CITY OF ALBUQUERQUE

RE: **Lot 2 Block 2 Unit 22 Volcano Cliffs**
8020 Canoncito Dr. NW (S.A.D. 228)
Grading and Drainage Plan
Engineers Stamp Date 2/2/17 (D10D0003C2)

ENGINEER'S SEAL 2/13/17	LOZOYA RESIDENCE 8020 CANONCITO DR NW	DRAWN BY: WCVJ DATE: 2-02-17
	GRADING AND DRAINAGE PLAN	21706-LAYOUT-2-01-17
 1606 CENTRAL AVENUE SE SUITE 201 ALBUQUERQUE, NM 87106 (505) 872-0999		SHEET # —
		JOB # 21706

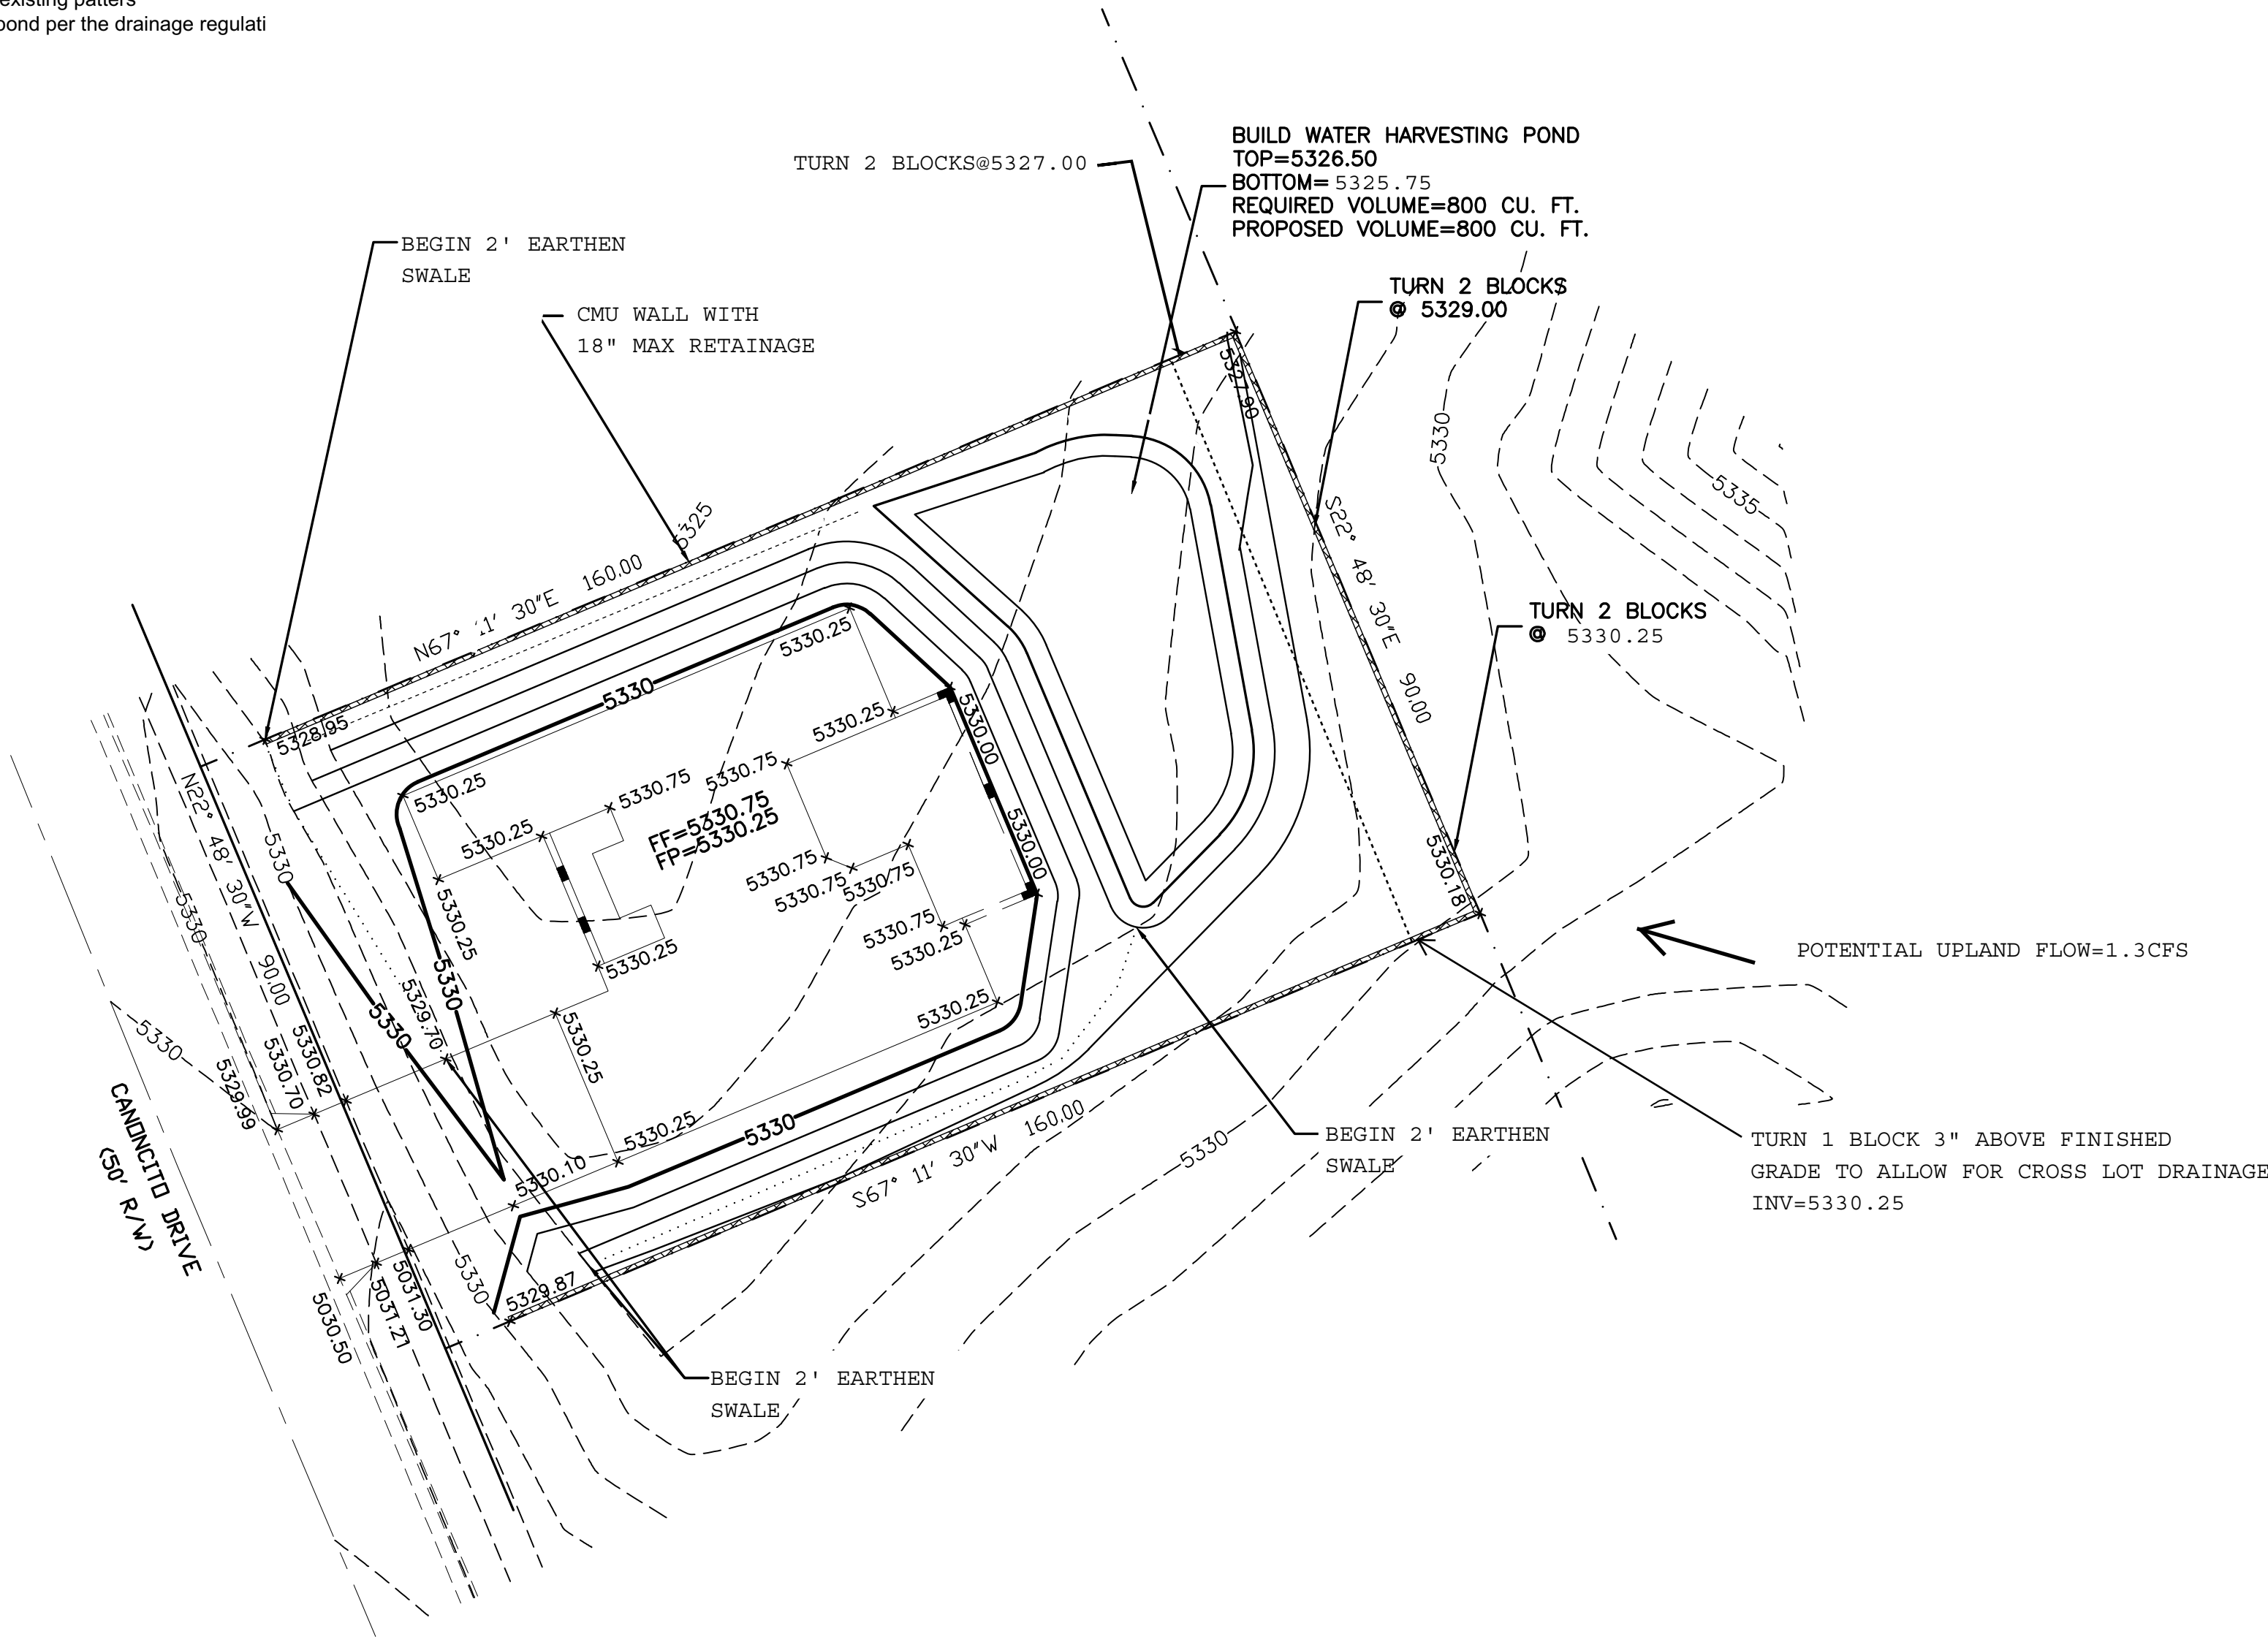
- The turn blocks are located wrong, the turn blocks should be located in the 10' PUE, which will allow flows to pass through the rear yard, accepting flows from the north heading south, eventually entering Kimmick Road.
- Show the 10' PUE in the rear yard. Provide a swale in the PUE, 1 foot away from the block wall.
- Along with the 3" above grade statement, place the height of the block as a spot elevation.
- Provide a statement that a pad certification is required before a Building Permit is released.
- Provide a statement that the block fence requires a separate permit and the approved grading plan must be provided with the plan set and permit.
